CITY OF ALBUQUERQUE

Re: Eclectic Restaurant Renovation

2119 Menaul Blvd. NE Traffic Circulation Layout

Architect's Stamp Date: 4/8/16; (H16D002)

A1 SITE PLAN - TCL
1" = 20'-0"

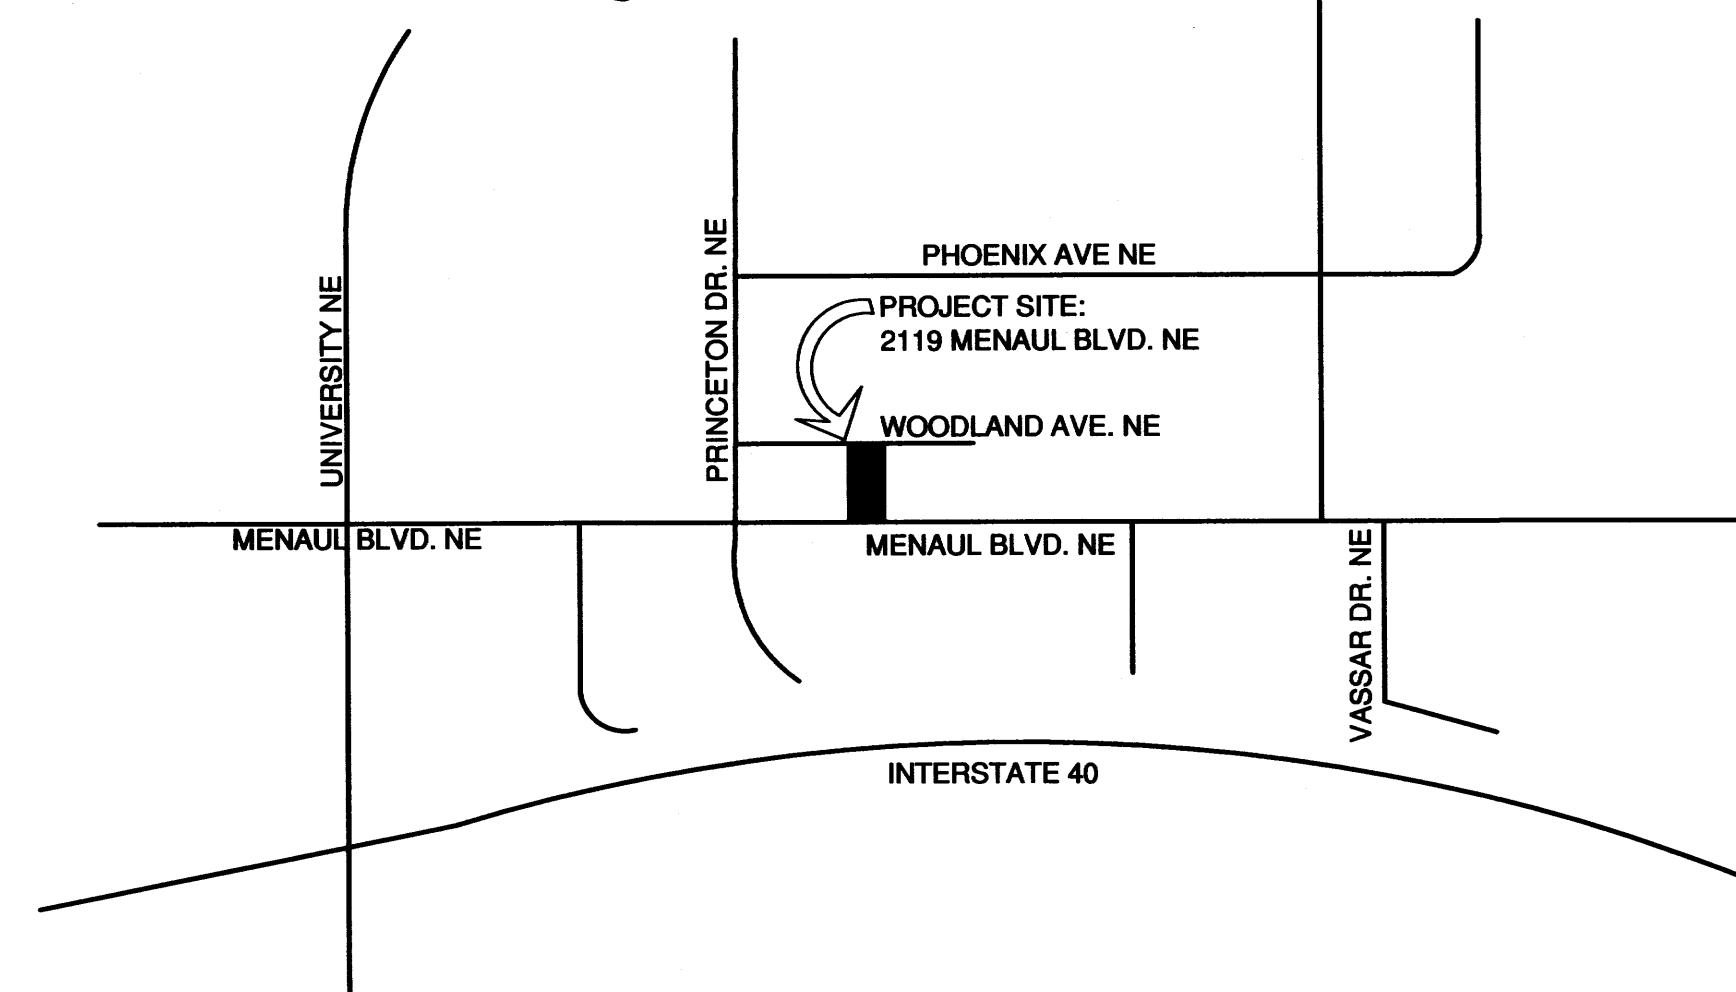
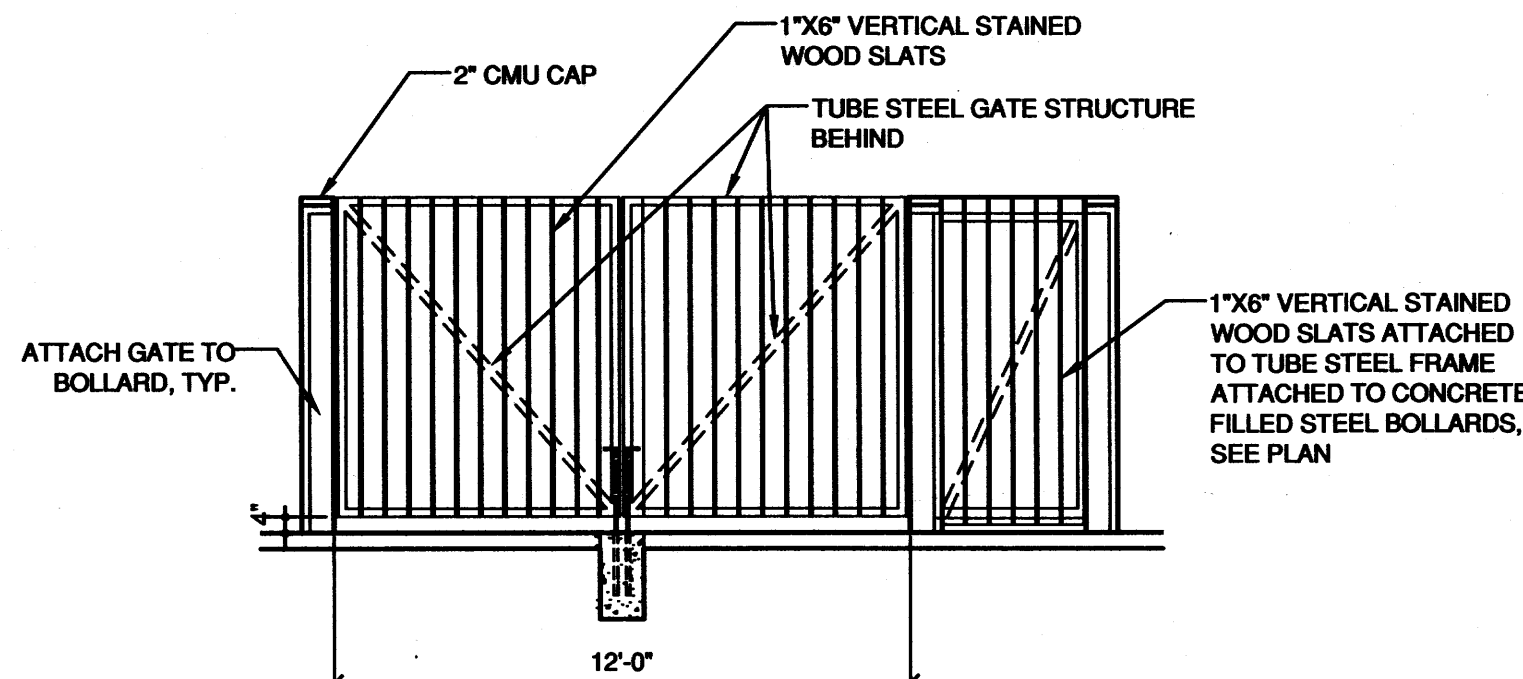
- 3. Identify the width of the curb cut adjacent to Menaul Blvd.
- 4. The ADA accessible parking sign must have the required language per 66-7-352.4C NMSA 1978 "Violators Are Subject to a Fine and/or Towing." Please call out detail and location of HC signs.

5. The ADA access aisles shall have the words "NO PARKING" in capital letters, each of which shall be at least one foot high and at least two inches wide, placed at the rear of the parking space so as to be close to where an adjacent vehicle's rear tire would be placed. (66-1-4.1.B NMSA 1978)

- 7. Per DPM, a 6 ft. wide ADA accessible pedestrian pathway is required from the HC parking stall access aisles to the building entrances. Please clearly show this pathway and provide details.
- 8. Design delivery vehicle route needs to be shown.
- Service vehicle and/or refuse vehicle maneuvering must be contained on-site;
 provide a copy of refuse approval.
- 10. Please specify the City Standard Drawing Number when applicable, for example, new sidewalk, new accessible ramp (Keyed Note 16), etc.
- 11. Is the accessible ramp (Keyed note 16) proposed or existing? If existing, does it meet ADA design standards?

A1 SITE PLAN - TCL
1" = 20'-0"

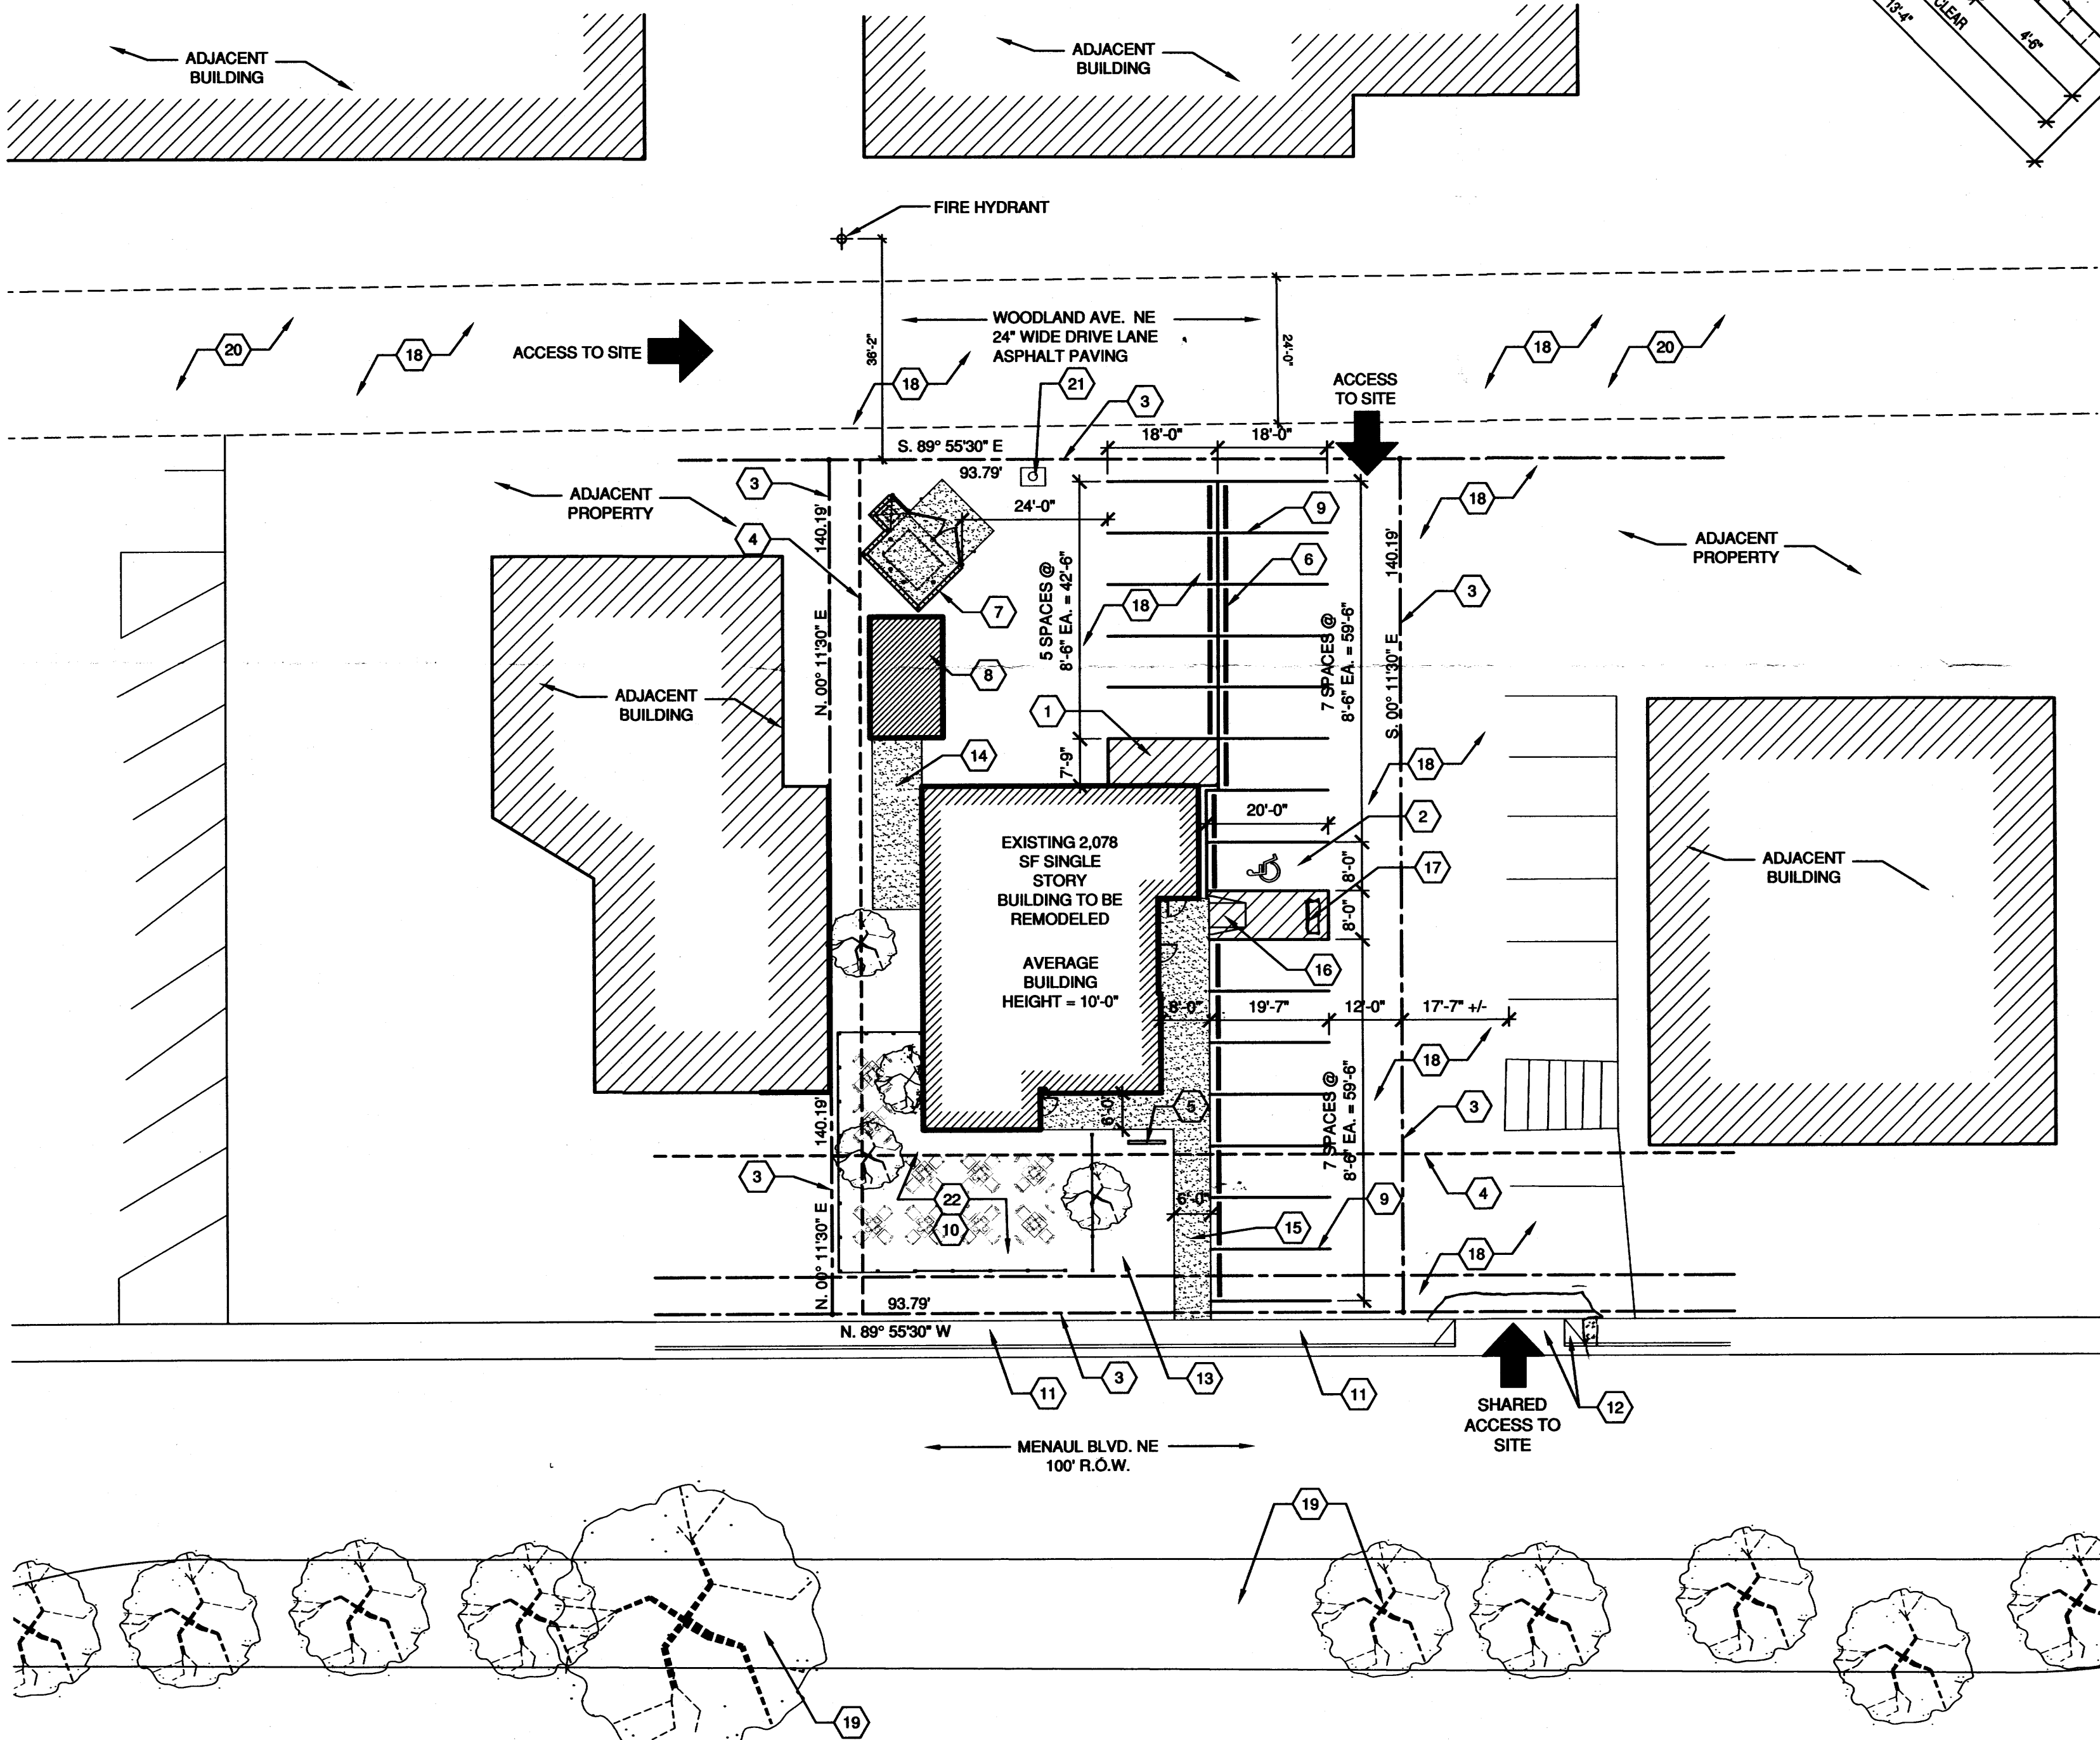
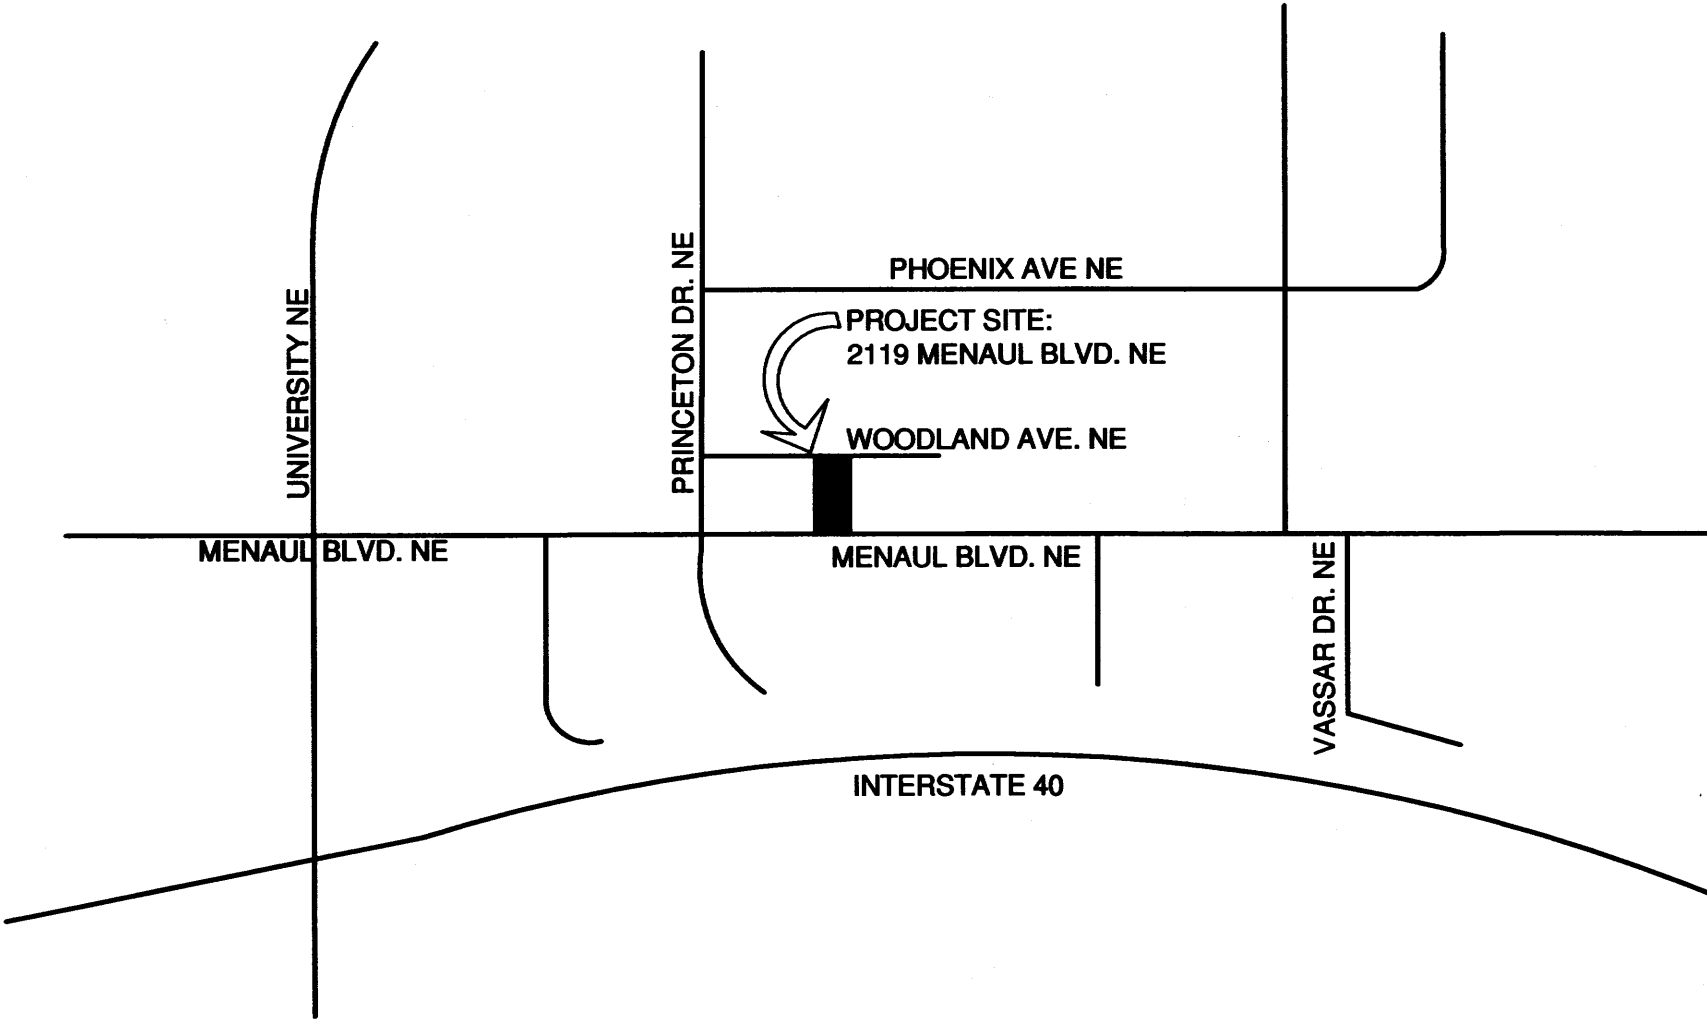
- 1. Please review and revise plan to provide all information listed on the attached Traffic Circulation Layout Check List.
- 2. Identify all existing access easements and right of way width dimensions.

6. Per DPM, a 6 ft. wide ADA accessible pedestrian pathway is required from the public sidewalk to the building entrances. Please clearly show this pathway and provide details.

- 12. Please include a copy of your shared access agreement with the adjacent property owner.
- 13. Please add a note on the plan stating "All improvements located in the Right of Way must be included on the work order."
- 14. All broken or cracked sidewalk must be replaced with sidewalk and curb & gutter. A build note must be provided referring to the appropriate City Standard drawing.
- 15. Please include two copies of the traffic circulation layout at the next submittal.
